WEST SUSSEX COUNTY COUNCIL CONSULTATION

TO:	Arun District Council FAO: Andrew Wood
FROM:	WSCC - Highways Authority
DATE:	4 December 2020
LOCATION:	54 Arundel Road, Littlehampton, BN17 7DD
SUBJECT:	LU/284/20/PL Demolition of 3 No. garages & erection of a four-room house of multiple occupation with shared facilities & parking for 3 cars (resubmission of LU/125/19/PL).
DATE OF SITE VISIT:	N/A
RECOMMENDATION:	Advice
S106 CONTRIBUTION TOTAL:	N/A

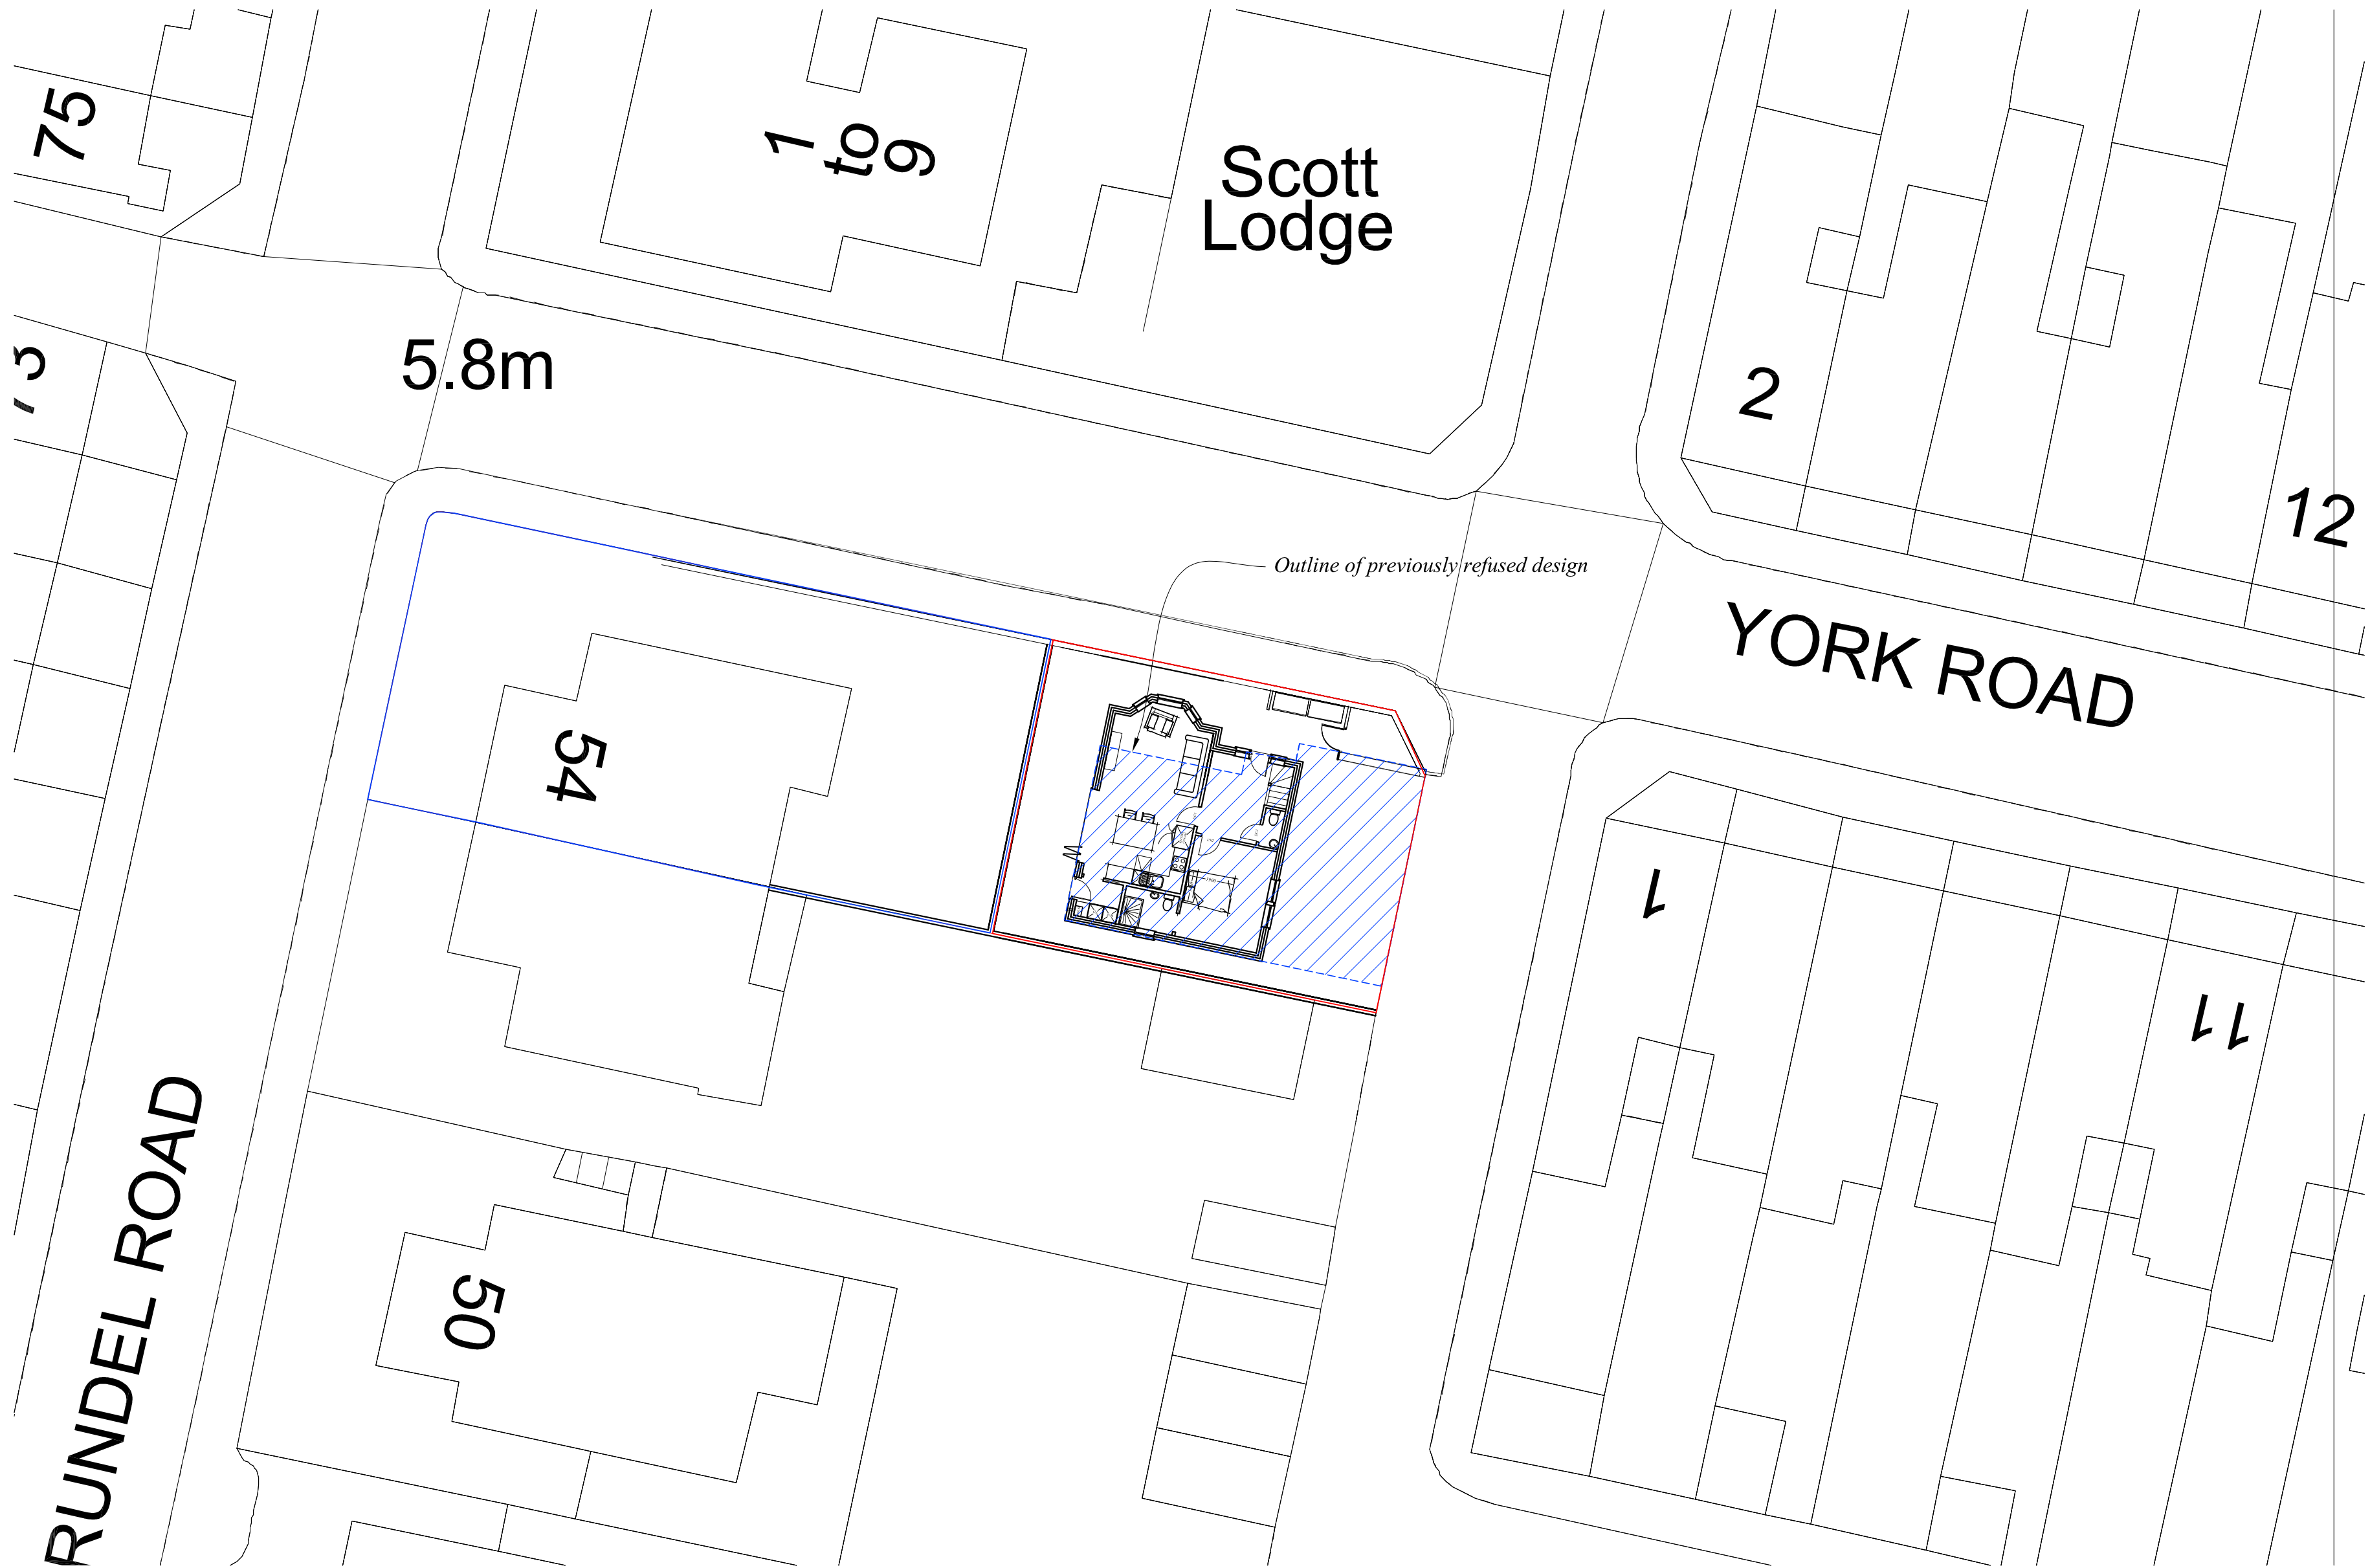
The proposed development will result in the loss of three garages. However, the applicant proposes three car parking spaces to the front of the proposed dwelling. Under WSCC parking standards, the LHA would anticipate a requirement of 0.5 spaces per bedroom and consequently, a demand for two parking spaces. Therefore, the LHA considers the proposed parking provision to be sufficient for a development of this size.

From inspection of the plans, the parking area is of a suitable size for three car parking spaces. On-site turning does not appear achievable, so vehicles may have to reverse out onto the private road. However, the LHA does not anticipate that this would have a detrimental impact on highway safety.

In regards to cycles, the applicant proposes a cycle store to the front of the proposed dwelling. The inclusion of secure and covered cycle parking provision helps promote the use of sustainable transport methods.

No part of the development shall be first occupied until the car parking has been constructed in accordance with the approved site plan. These spaces shall thereafter be retained at all times for their designated purpose.

No part of the development shall be first occupied until covered and secure cycle parking spaces have been provided in accordance with plans and details to be submitted to and approved by the Local Planning Authority.
